# KITTITAS COUNTY

### MEMORANDUM

**TO:** All Staff  
**FROM:** Public Works Plan Review Team  
**DATE:** October 11<sup>th</sup>, 2023  
**SUBJECT:** Public Works Comments: VA-23-00008 Hendrix

**SITE PLAN**  
**LOT 1, BLOCK E, PINE LOCH SUN I**  
**A PORTION OF THE SW 1/4 OF THE NE 1/4 OF SECTION 2,**  
**TOWNSHIP 20 NORTH, RANGE 14 EAST, W.M.,**  
**KITTITAS COUNTY, WASHINGTON**

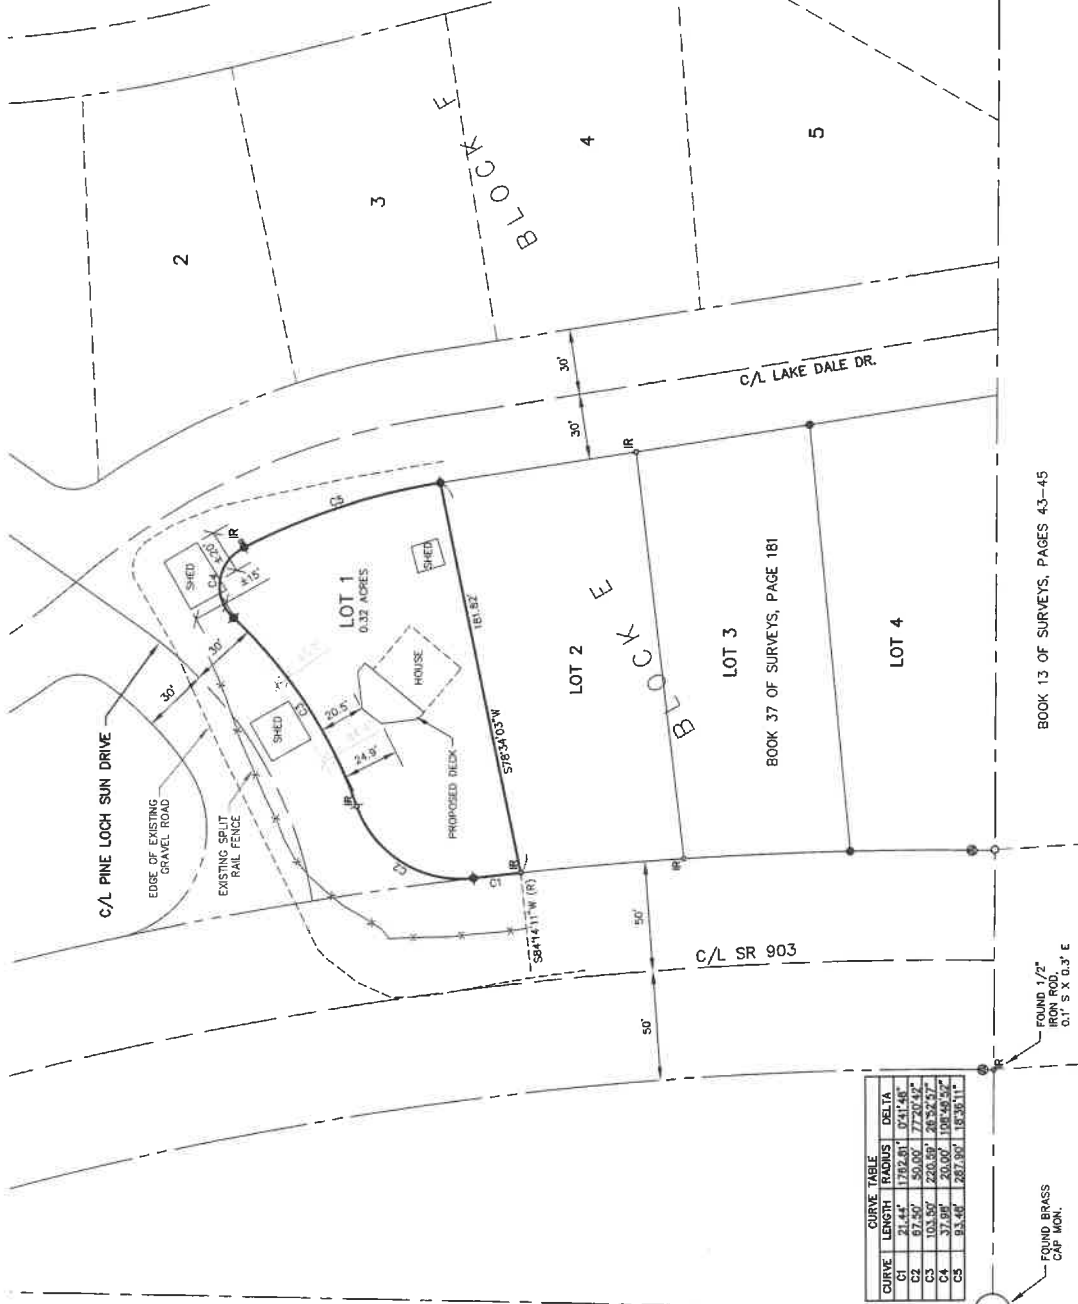
<b>SURVEY</b>	<ol style="list-style-type: none"> <li>1. Given the tight tolerances, it is highly recommended that the garage be staked out by a land surveyor licensed in the State of Washington.</li> <li>2. Given the tight tolerances, no portion of swinging doors, eaves, or building footings should extend into the remaining 7.5' setback.</li> </ol>
<b>TRANSPORTATION CONCURRENCY</b>	<p>No transportation concurrency application will be required for this project. (KAH)</p>
<b>FLOOD &amp; WATER MITIGATION/ METERING</b>	<p>No comments. (SC)</p>
